**Consultation Response from KC,  
Trees**

**2024/92140 16, Town Gate, Upperthong, Holmfirth, HD9 3UX**

**Erection of detached garage (within a Conservation Area)**

**Date Responded: 16/08/2024**

Proposed Site Plan - 1:100

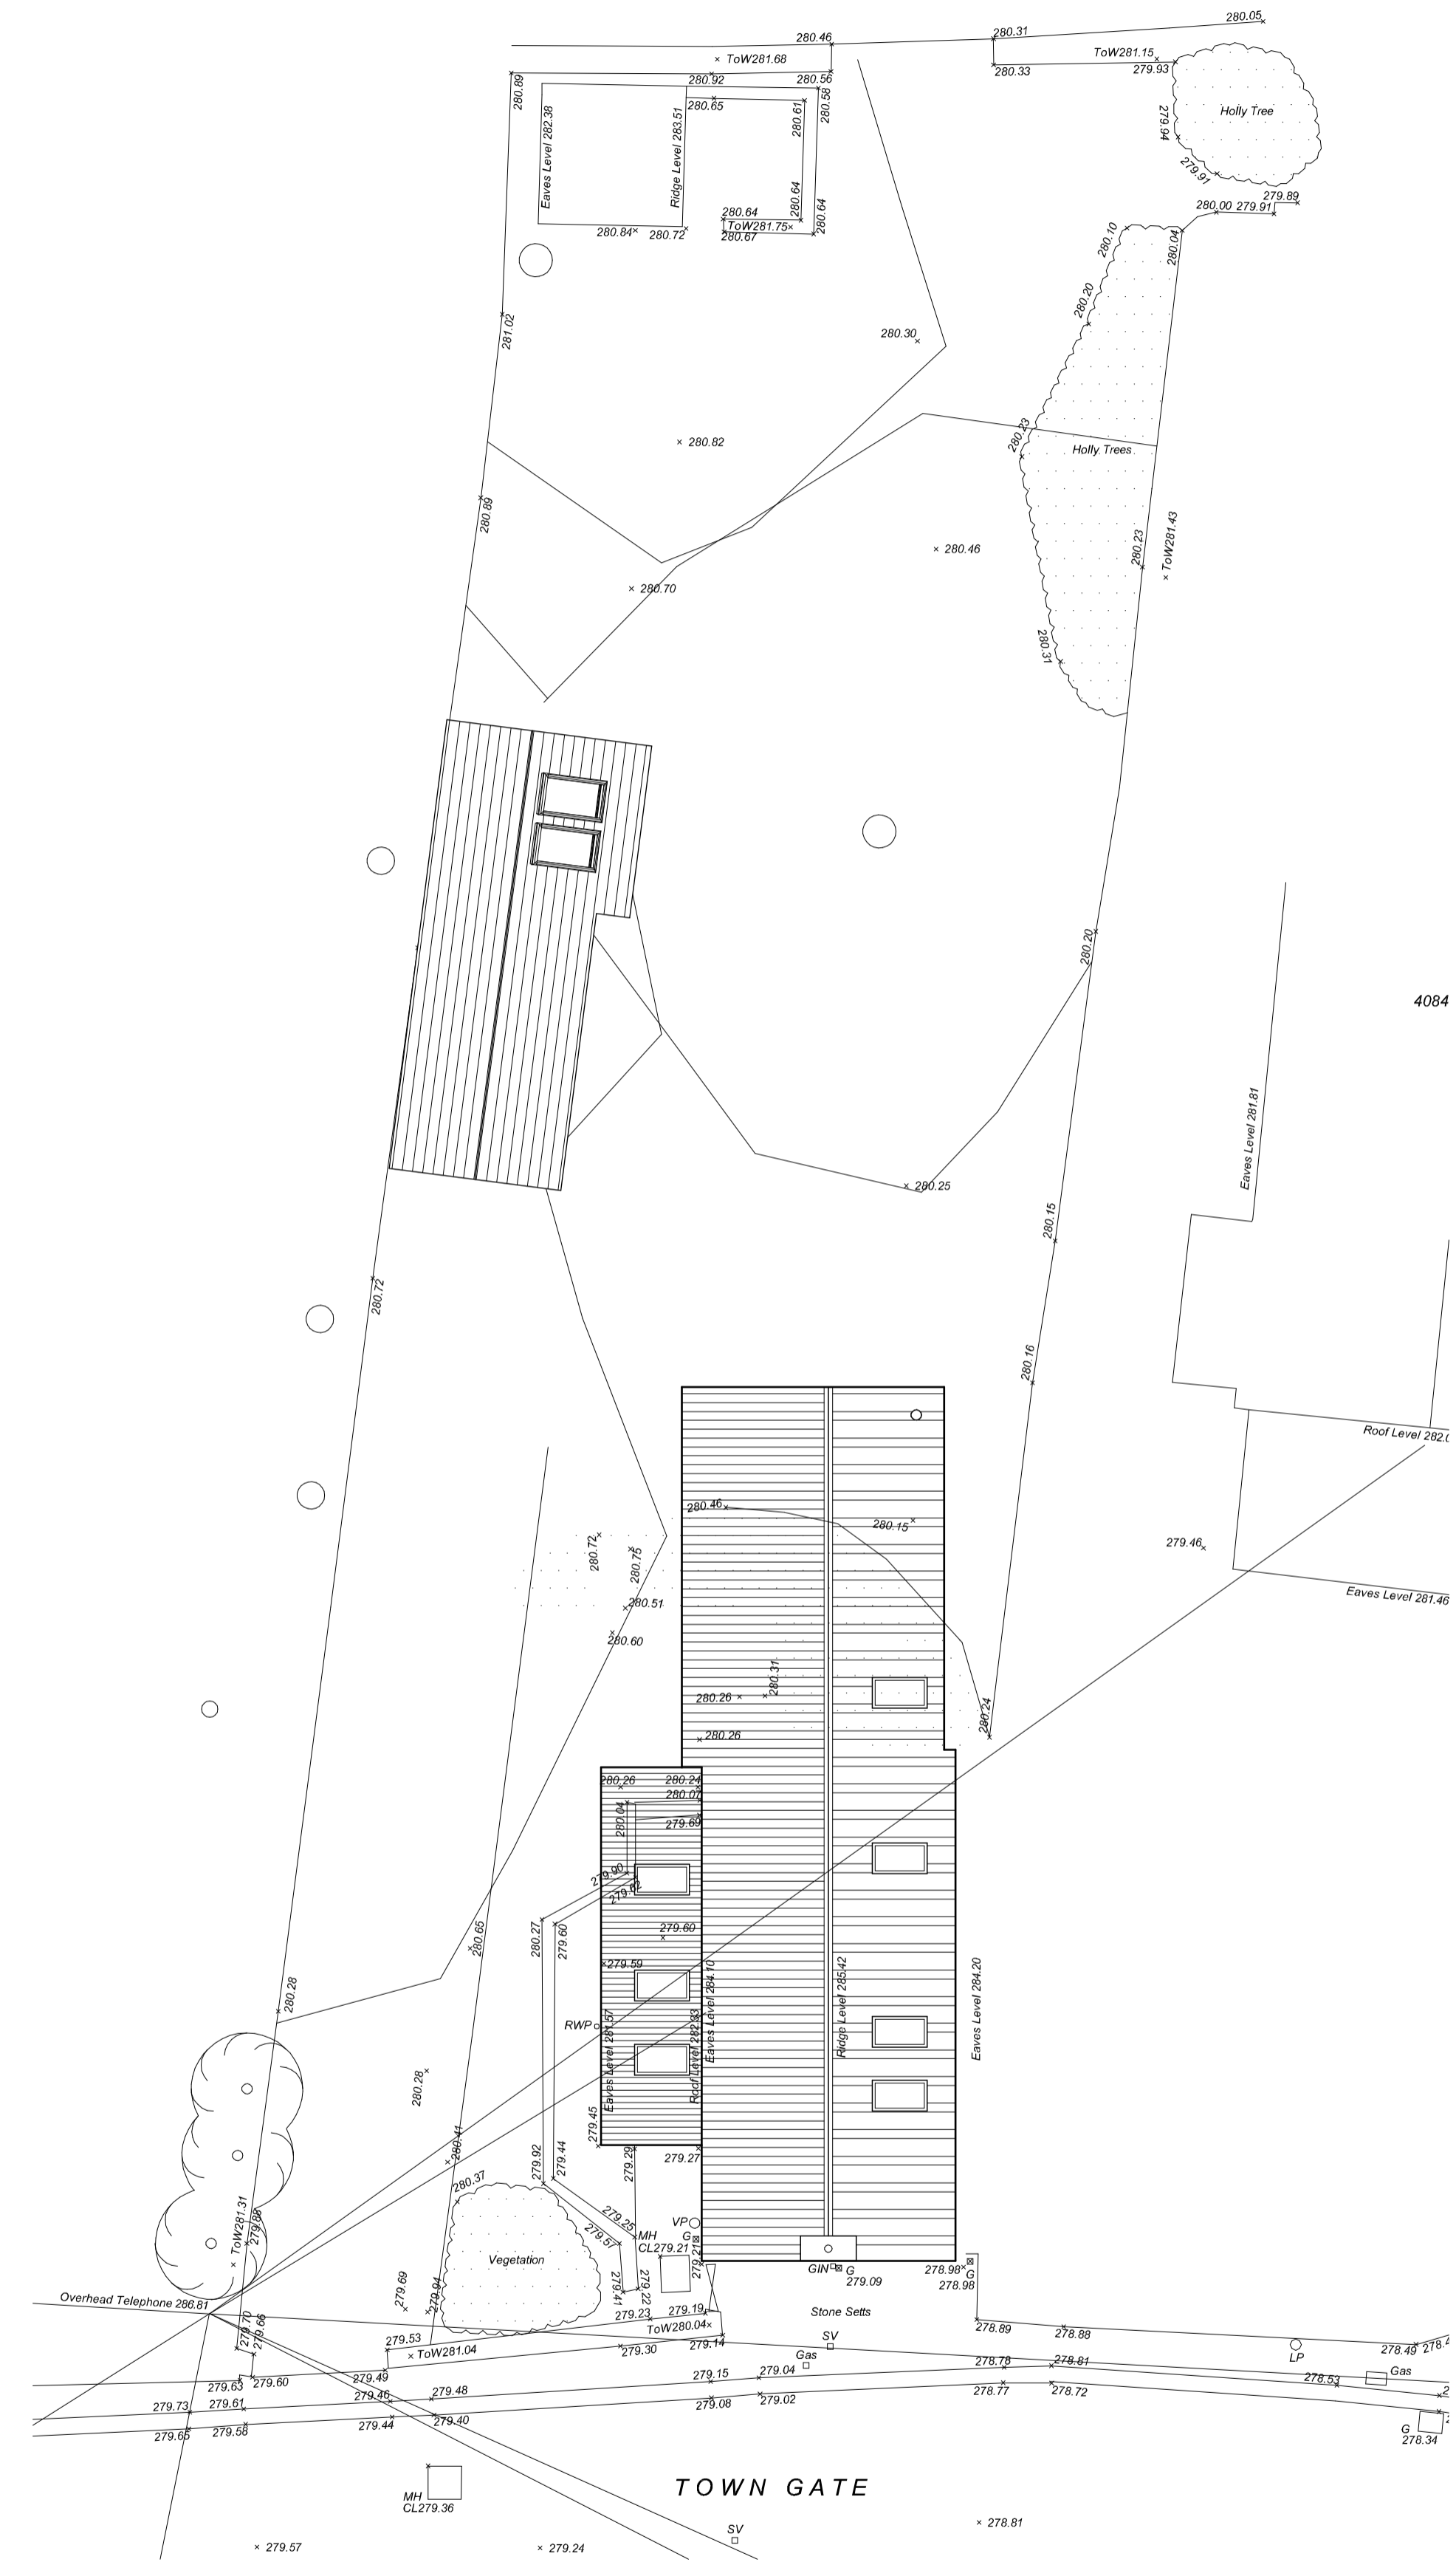
The proposals are adjacent to tree protected under the Upperthong conservation area. There is likely to be an impact on these trees but there has been no tree specific information submitted as part of the application and therefore an assessment of the impact on the surrounding trees cannot be undertaken. There is a holding objection until an Arboricultural Impact Assessment (AIA) and an Arboricultural Method Statement (AMS) is submitted which details the impact on the surrounding trees and how they may be protected throughout construction.
